**The Examining Authority's Written Questions
Issued on 21 April 2021**

**Answers from the
Royal Society for the Protection of Birds
and Suffolk Wildlife Trust**

**Application by NNB Generation Company (SZC) Limited for an Order
Granting Development Consent for
The Sizewell C Project**

**Planning Inspectorate Ref: EN010012
RSPB Registration Identification Ref: 20026628
Suffolk Wildlife Trust Registration Identification Ref: 20026359**

DRAWING NO:
SZC-SZ0100-XX-000-DRW-100207

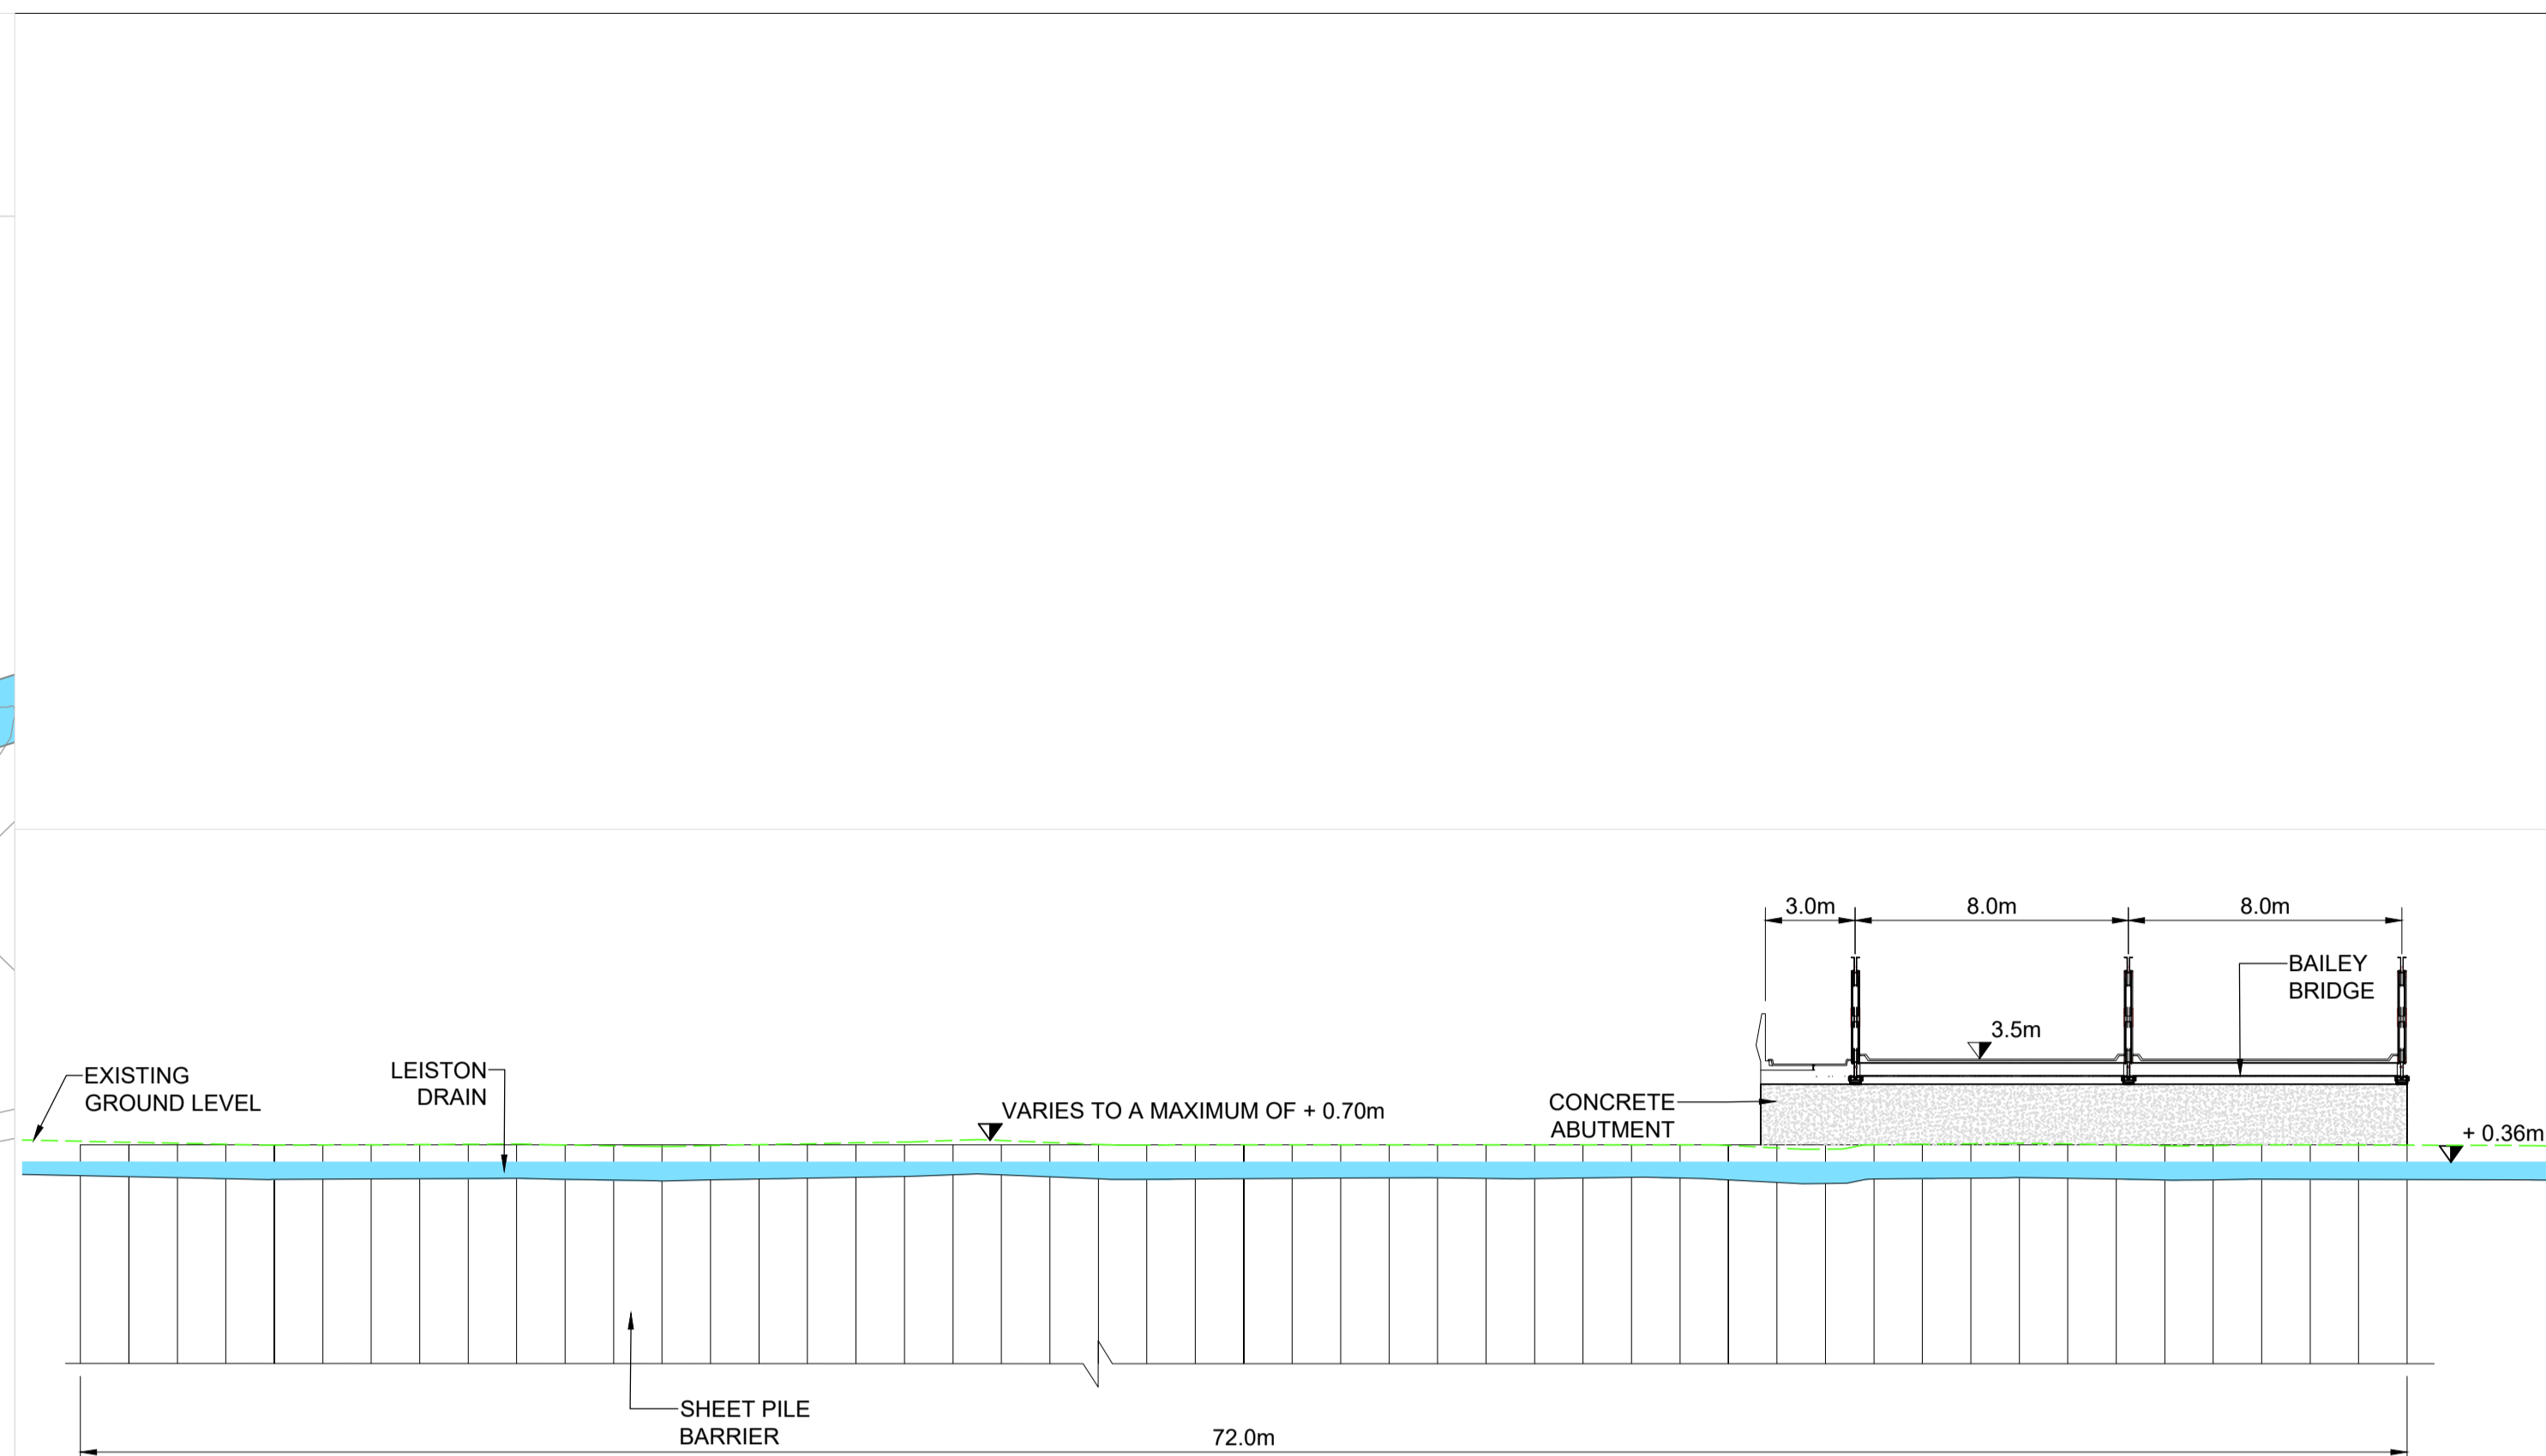
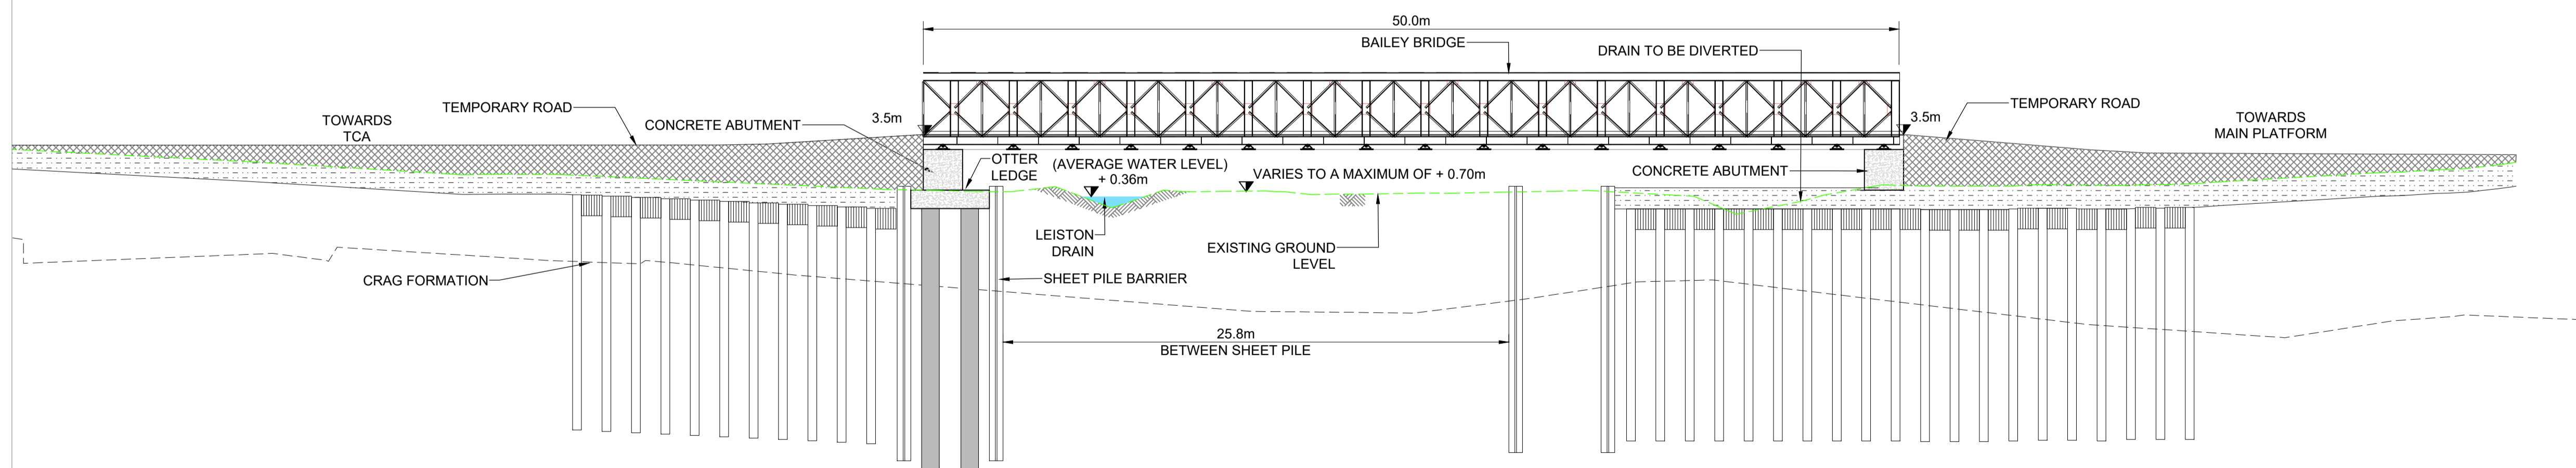
9. There are three major developments that have the potential to have a major impact on the sensitive ecohydrological functioning of the wetland system. These are:
 - The new cut-off wall adjacent to the platform base for the new site, and related internal lowering of groundwater levels (dewatering) during the construction phase;
 - The re-routing of the Sizewell Drain; and
 - The new crossing at the drainage outlet for the Sizewell Drain and the Leiston Drain.

11. A free span bridge would be far less impacting, as it would leave a significantly wider corridor unchanged, to facilitate original hydraulic control and subsurface drainage of the SSSI site.
